Our Ref: BN/86/21/DOC

Approval of details reserved by condition imposed under ref BN/32/15/OUT relating to Condition No 6 - surface water drainage.

Land Rear of Lillies Yapton Road Barnham PO22 0AY

Arun District Council have decided to **REFUSE details reserved by condition for the following reasons:**

DETAILS SUDS CROSS SECTION

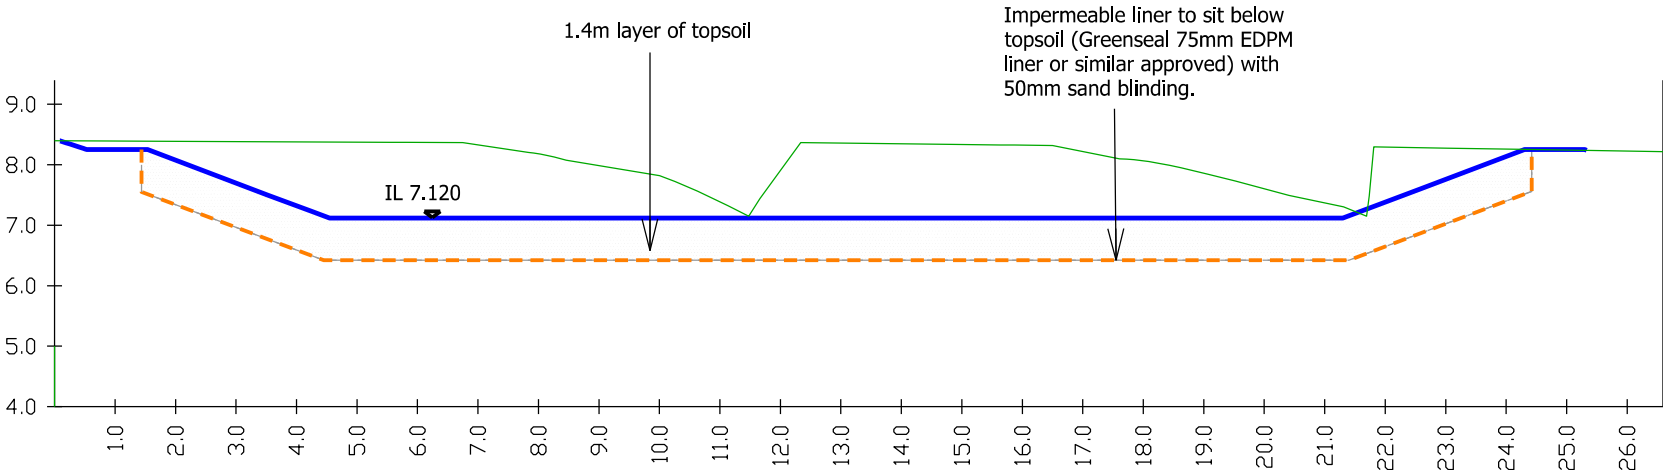
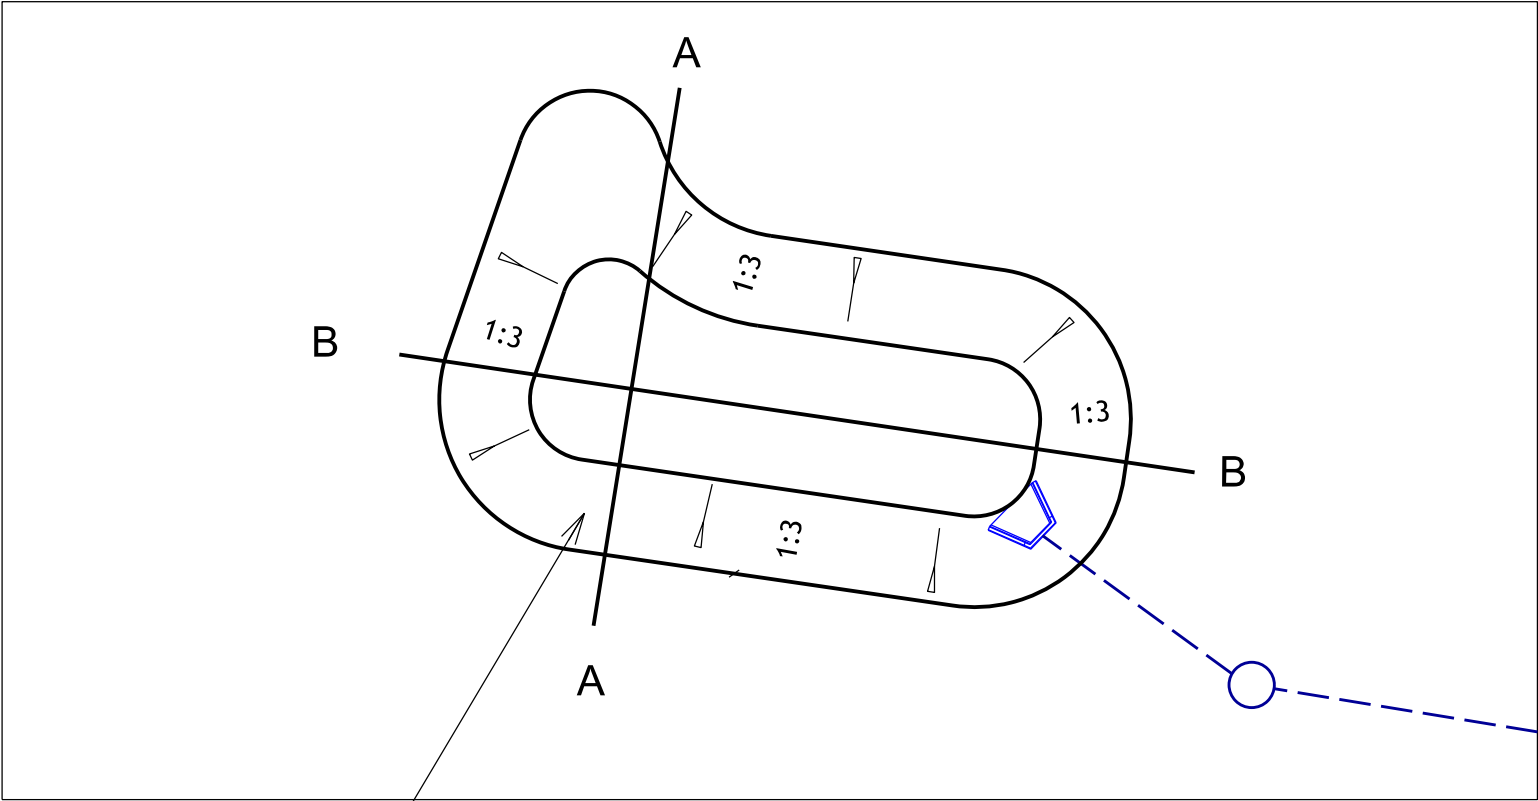
The groundwater monitoring data submitted as part of this application to alter the basin design does not include any monitoring completed at the location of the proposed basin. It is also noted that half of the monitoring boreholes were deemed to have been impacted by on-site dewatering activities. Monitoring was not completed over the full winter with no data provided between mid-December and mid-February. As a result of these factors it is deemed that the groundwater monitoring results presented cannot be relied upon. Without adequate monitoring it has not been evidenced that the revised design would not increase on site or off-site flood risk for the duration of the development, contrary to Policy W DM2 of the Arun Local Plan.

Condition 6 was previously discharged under BN/129/20/DOC; and the basin design approved under BN/129/20/DOC is still suitable.
